11 Brown St - sign permit #1876

BRGR
**MODIFIED
 PLAN**

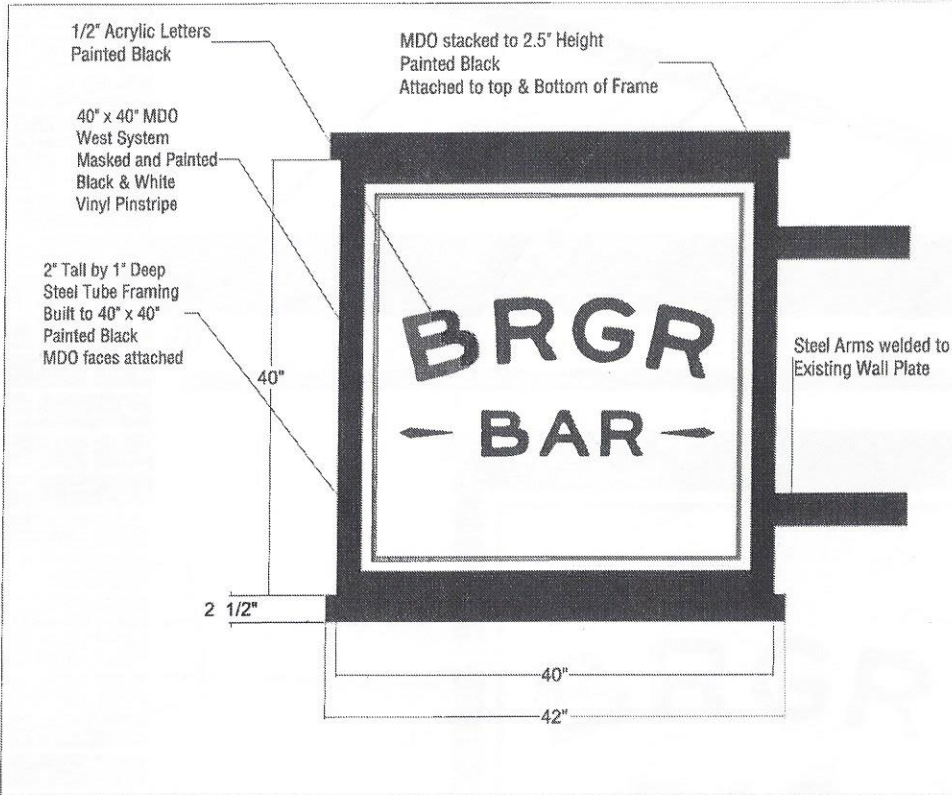
I was taking a first look at the sign permits for BRGR Bar and had a question. The plans show that the yellow awning was to be removed and replaced with some sort of new awning or projecting feature (it is hard for me to tell from the plans the exact nature of the new feature). Has this work already occurred? If not, is it proposed now?

Thanks for reaching out. We did remove the awning but have not replaced with the corten awning we had originally planned and shown to the HPC due to the cost. It may still be a future project but is on hold for now. If we do want to move forward down the road with the corten should I be filling out a separate application with you? Thanks for all your help!
